10 April 2018

SF2017/117114; WST08/00023/13

SSD6084_ MOD 1: Austen Quarry Extension Project

Figure 2: Austroads Turn Treatment Warrants

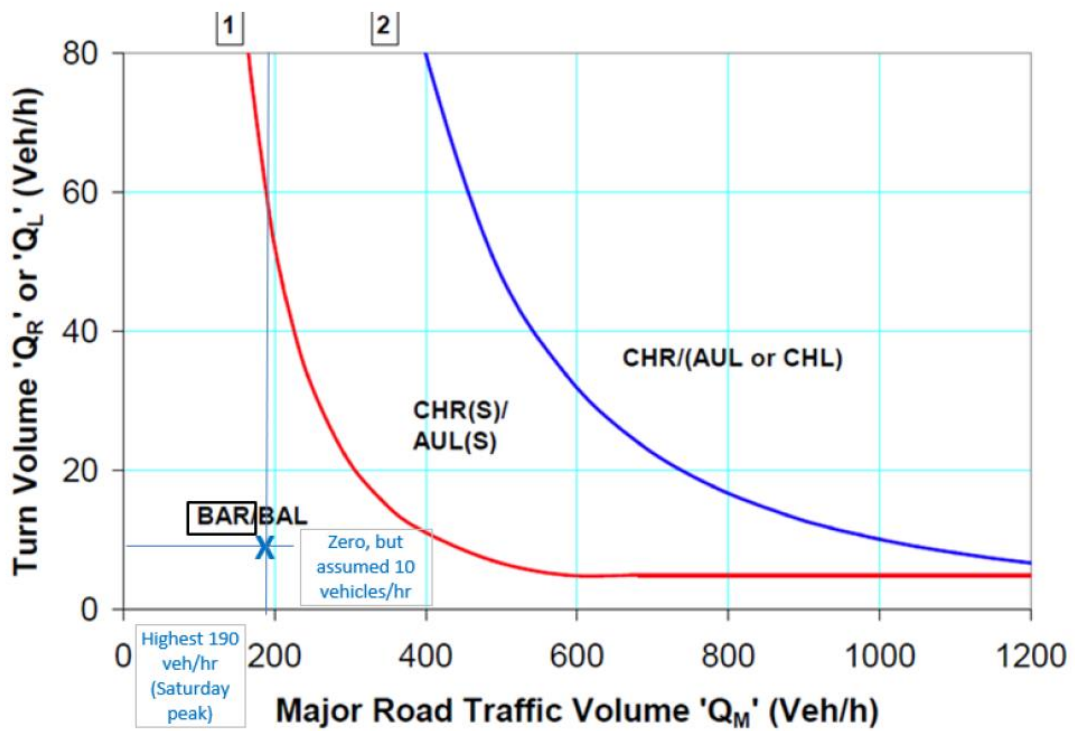
- Prior to the commencement of Modification 1, a Channelised Right turn lane Short [CHR(s)] in accordance with Figure A29 Part 4 *Austroads Guide to Road Design 2017* (copy enclosed) and relevant Roads and Maritime supplements, is to be provided in Jenolan Caves Road at its intersection with the site access. The intersection works are to be designed and constructed for an 80km/h speed zone and be able to accommodate the largest vehicle accessing the intersection.
